## **Suffolk County Council (20041323)**

Additional Evidence relating to the  
Landscape and Ecological Management Plan

## **Bramford to Twinstead (EN020002)**

Deadline 6

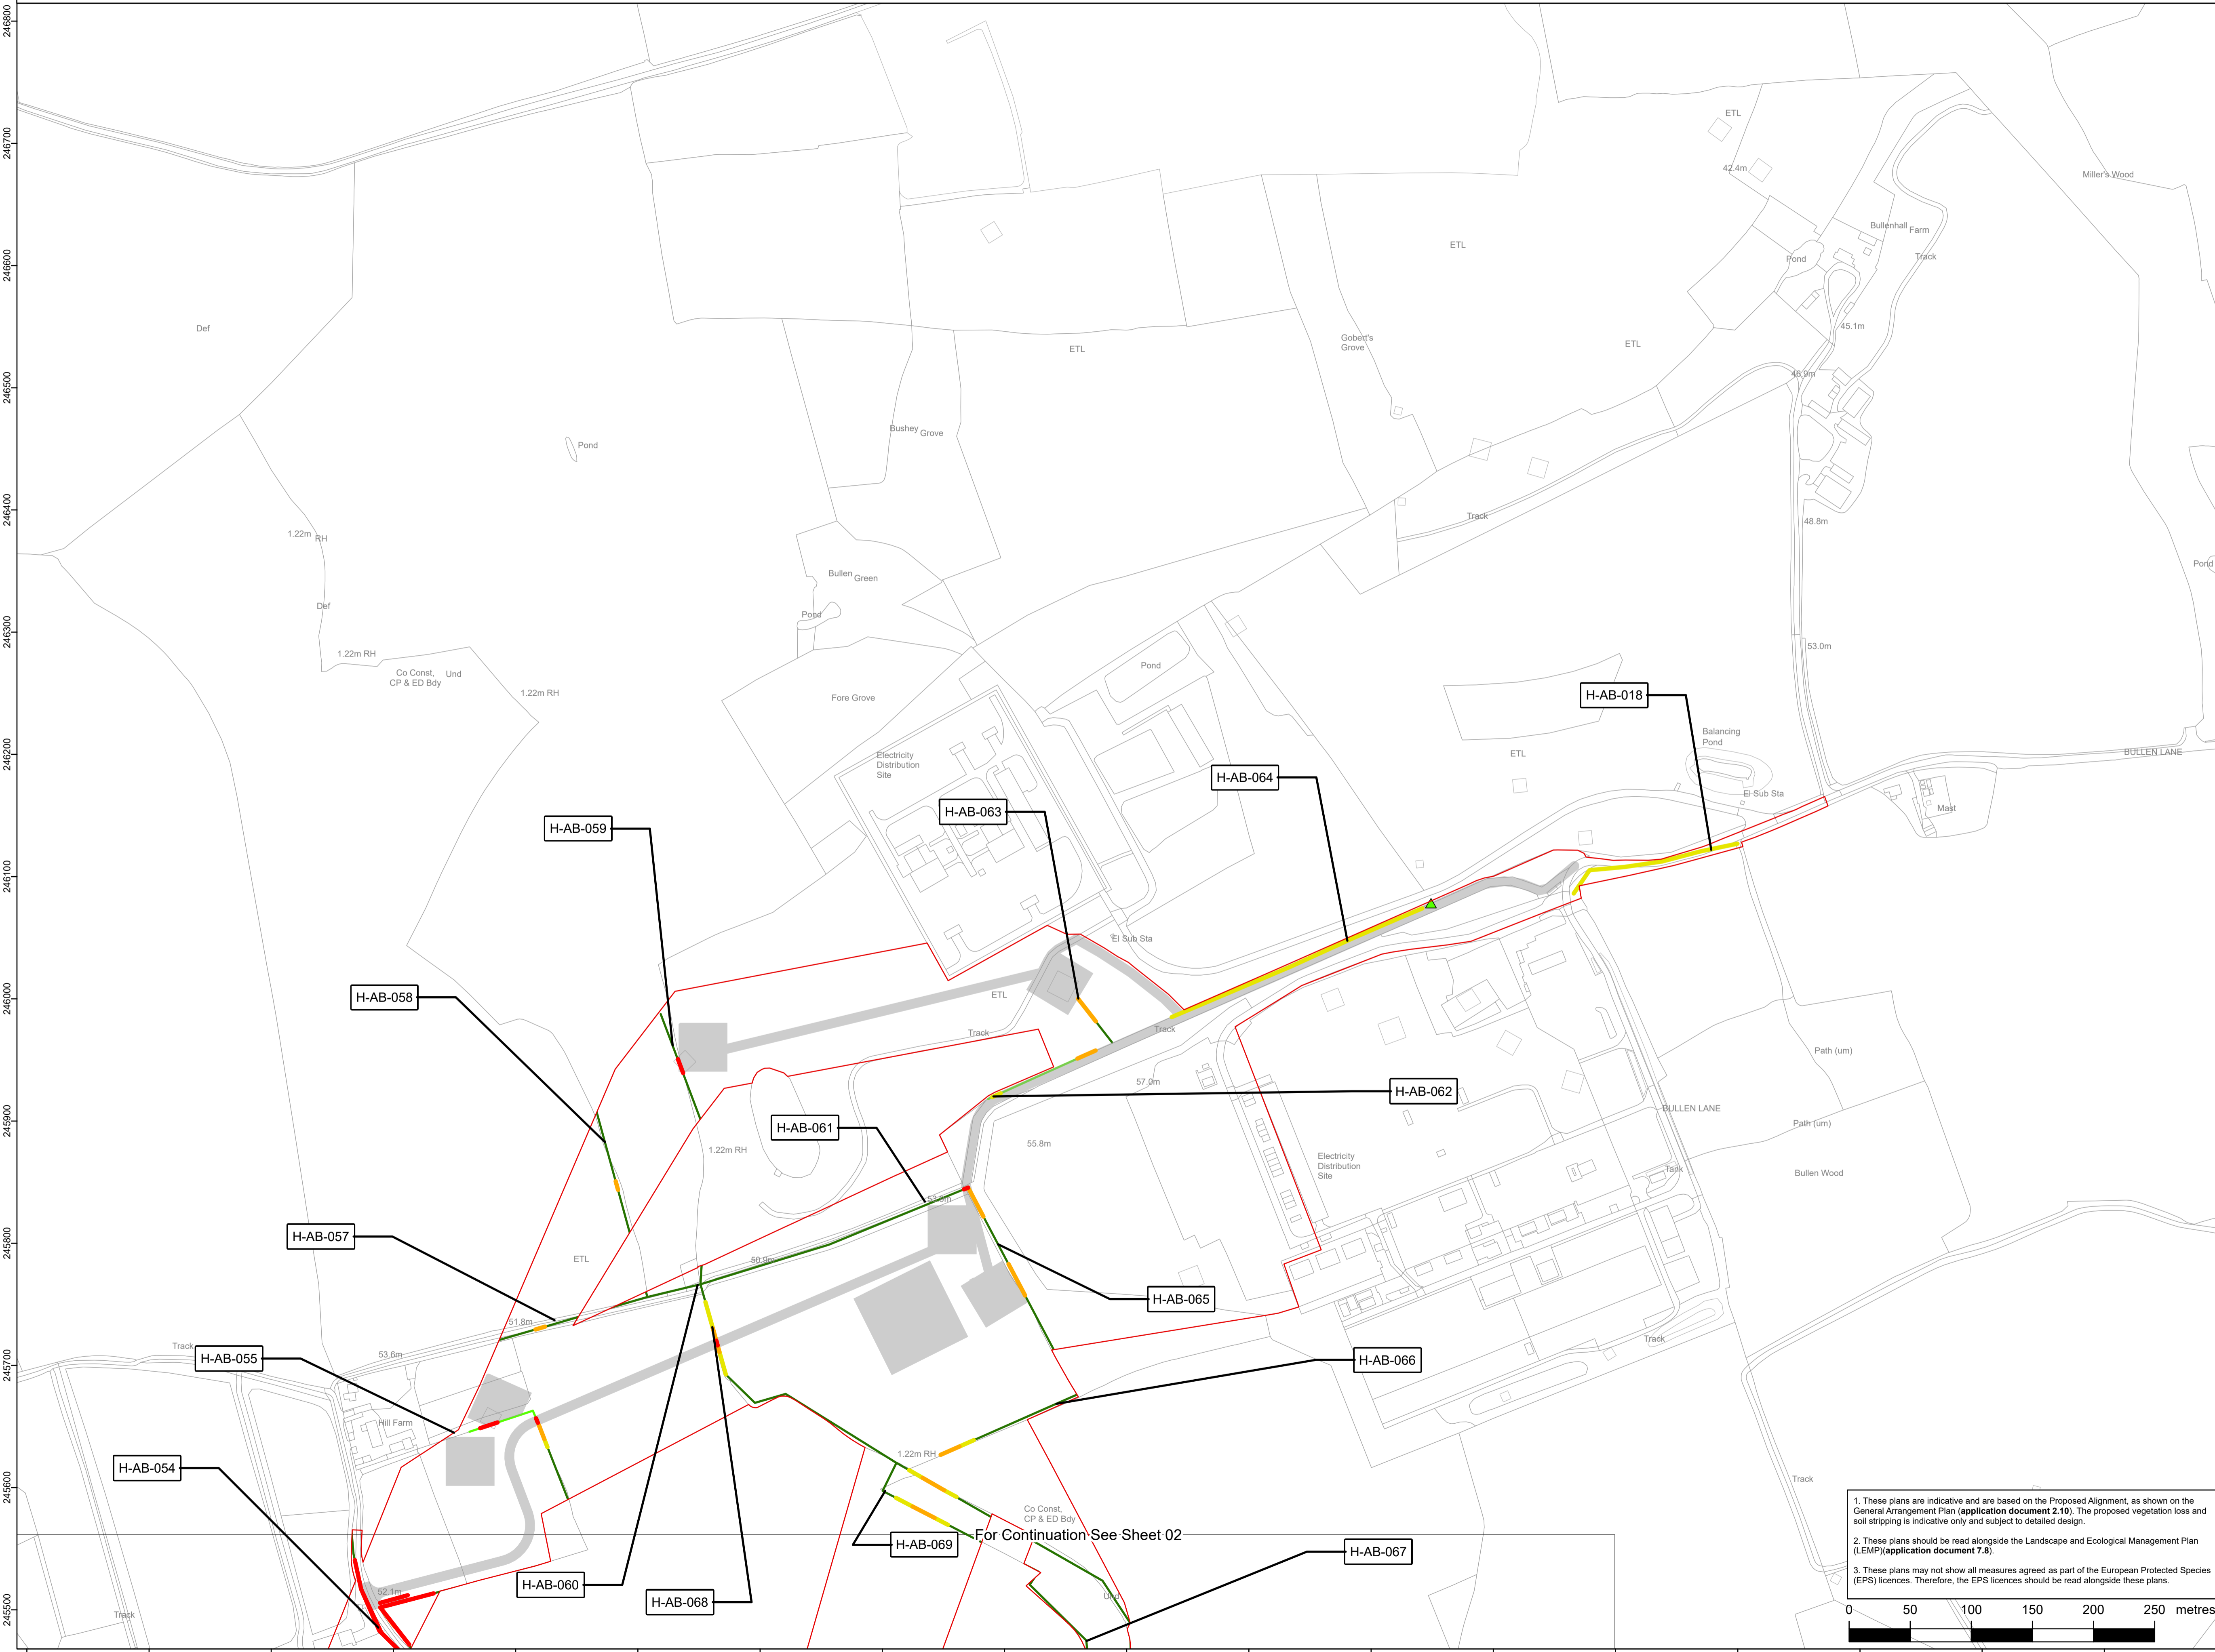
- 1.6.a Example: Sheet 1, H-AB-018 (important hedge), and H-AB-064 (non-important hedge) are both shown as 'Hedgerow/Line of trees to be pruned.
- 1.7 Even where hedges are identified as important, information about the species contained within the hedge are not available for many hedges, yet Hedge mix H1 is considered appropriate to be specified for reinstatement.

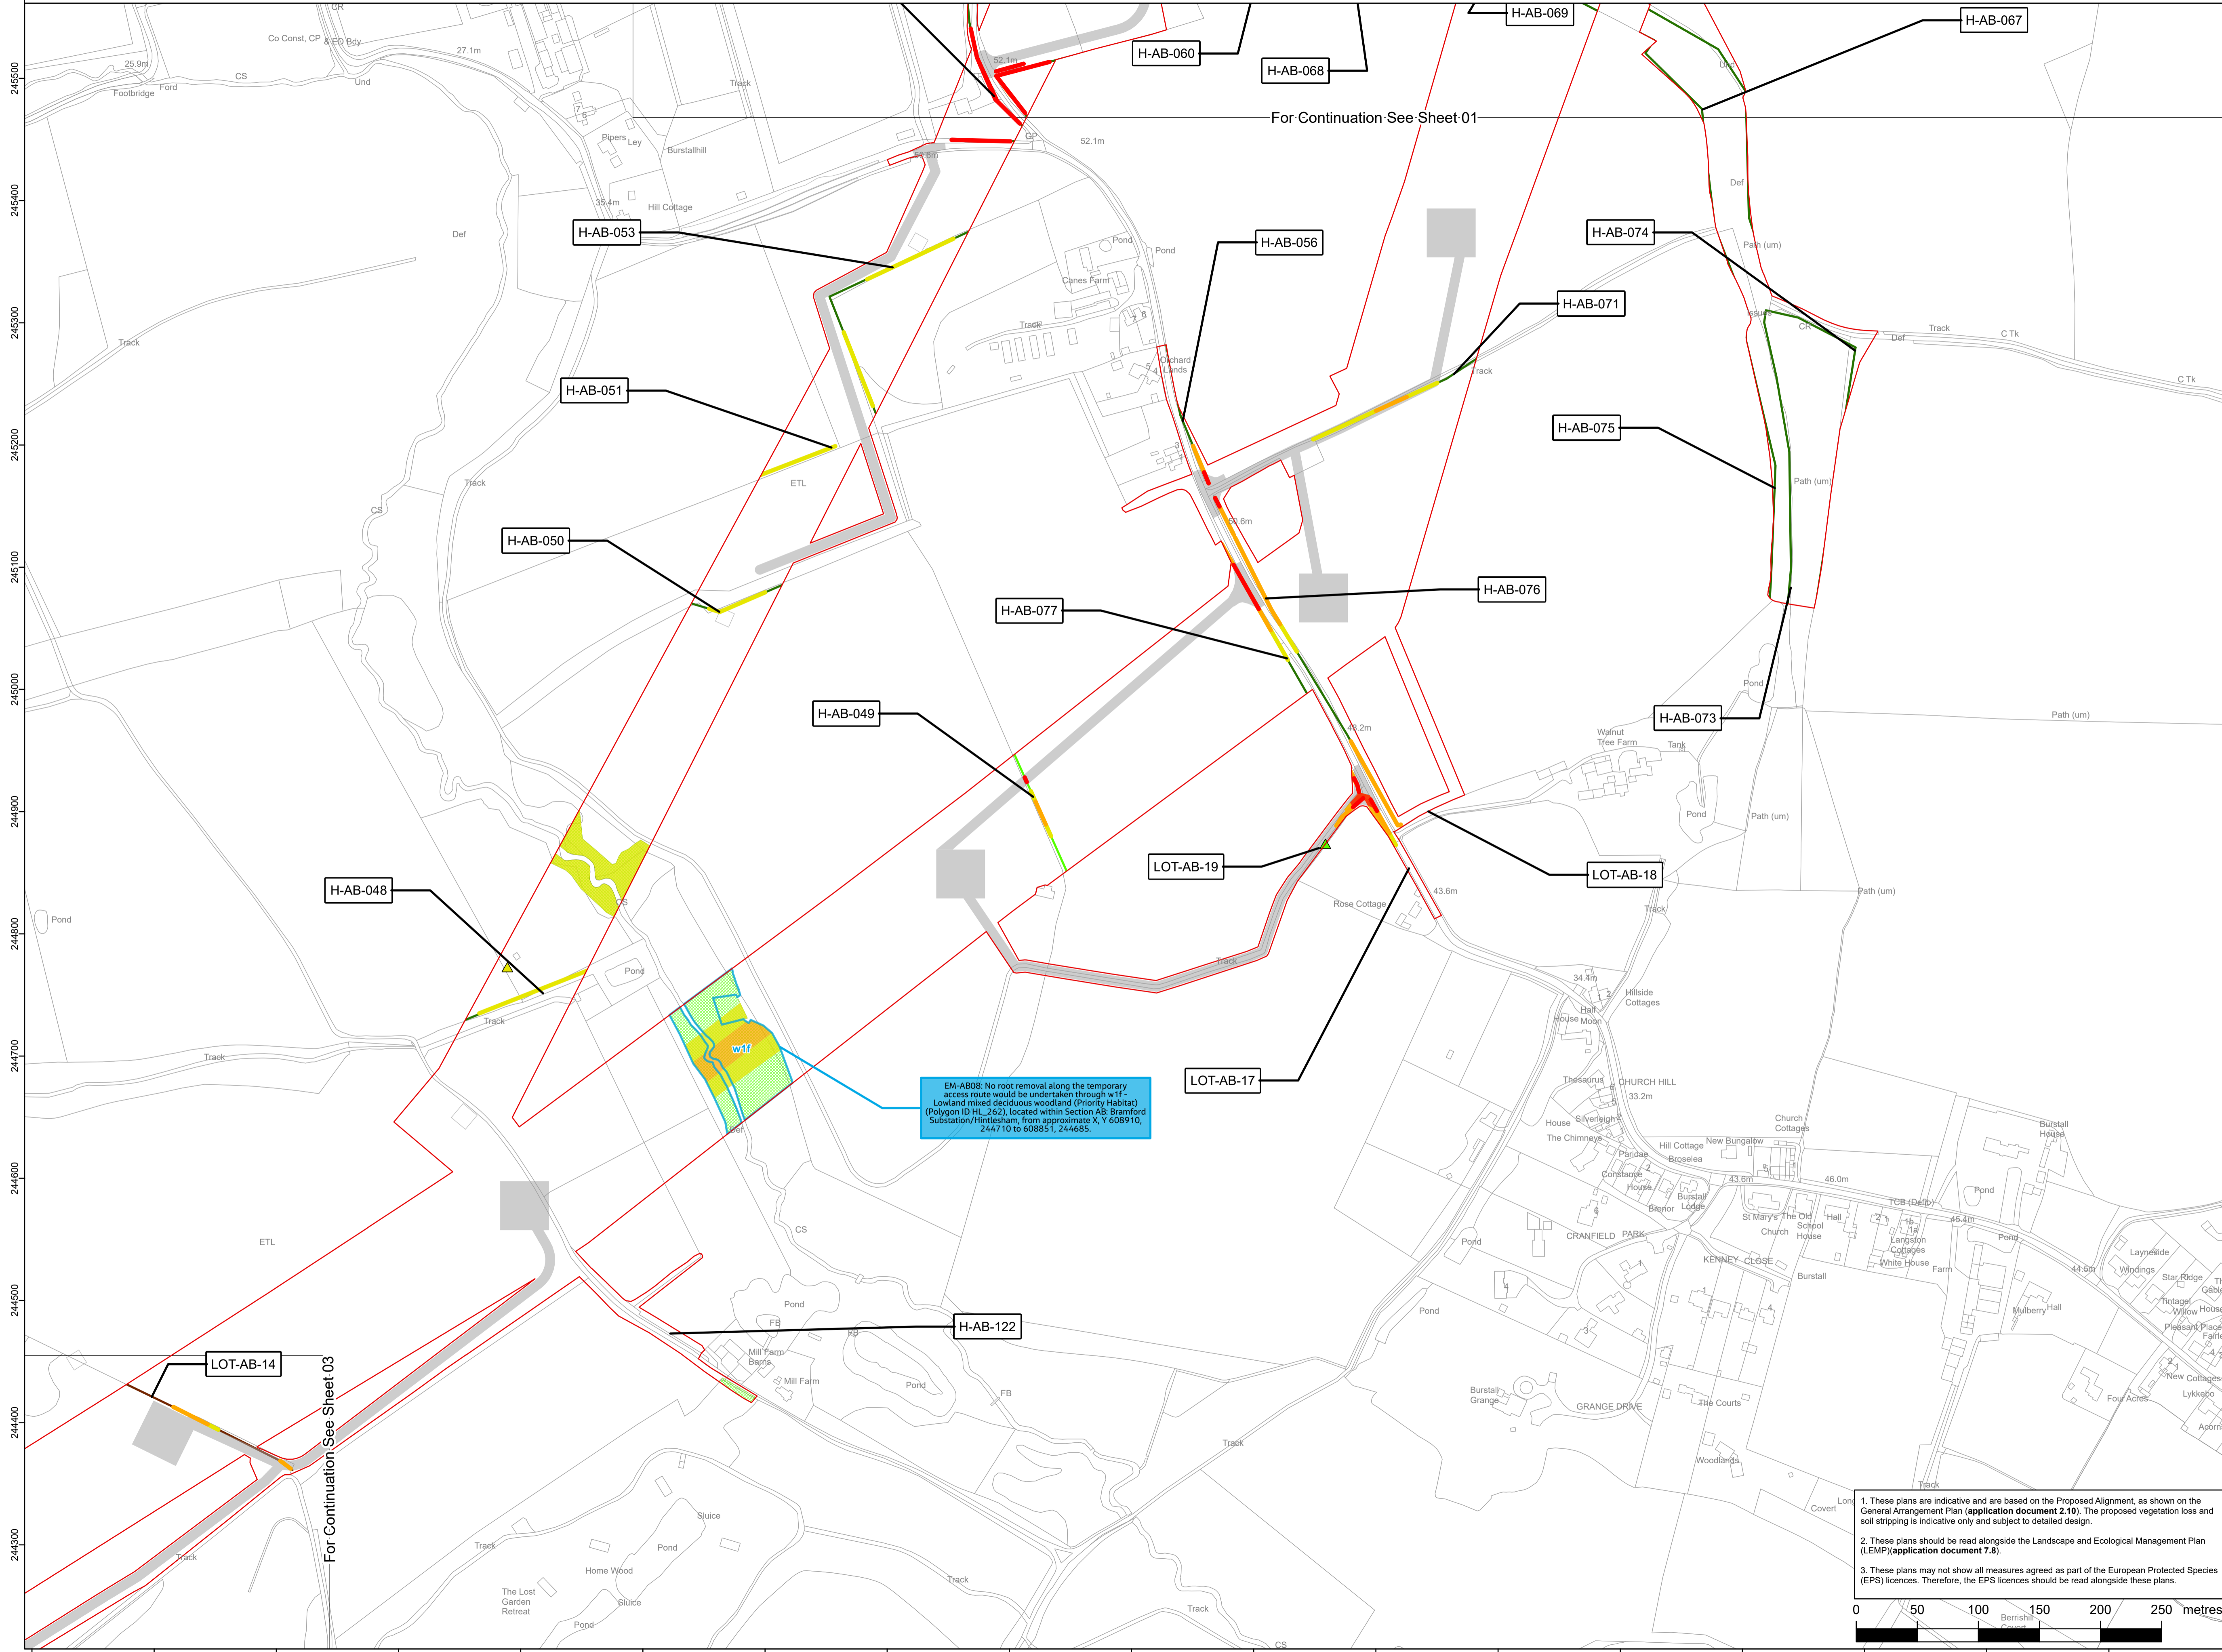
- 1.1.b Both the Vegetation Retention and Removal Plan and the Vegetation Reinstatement Plan show a tree (Sheet 02, near H-AB-048) as requiring pruning and then being allowed to regrow naturally. This tree is not shown in Figure 1 Results of Arboriculture Survey (Sheet 1).

- 1.1.d The woodland/group in the south-eastern corridor is identified as wf1 (blue label EM-AB08 on Vegetation Retention and Removal Plan, Sheet 02). As the Arboricultural Survey identified this as Category U, it would be expected that this woodland would benefit from positive

- 1.5.b Actions and prescriptions
- 1.5.b.1 EM-AB08 (blue label on Vegetation retention and Removal plan, Sheet 02) states: No root removal along the temporary access route would be undertaken through w1f - Lowland mixed deciduous woodland (Priority Habitat) (Polygon ID HL\_262), located within Section AB: Bramford Substation/Hintlesham, from approximate X, Y 608910, 244710 to 608851, 244685.

- 1.8 Opportunities for additional mitigation are being missed.
  - 1.8.a For example, along PRow w-174/011/0, between Churchill, Burstall, and H-AB071 (Sheet 02 Vegetation Retention and Removal Plan), the hedge should be extended to the road to afford additional visual mitigation for views towards Bramford substation.
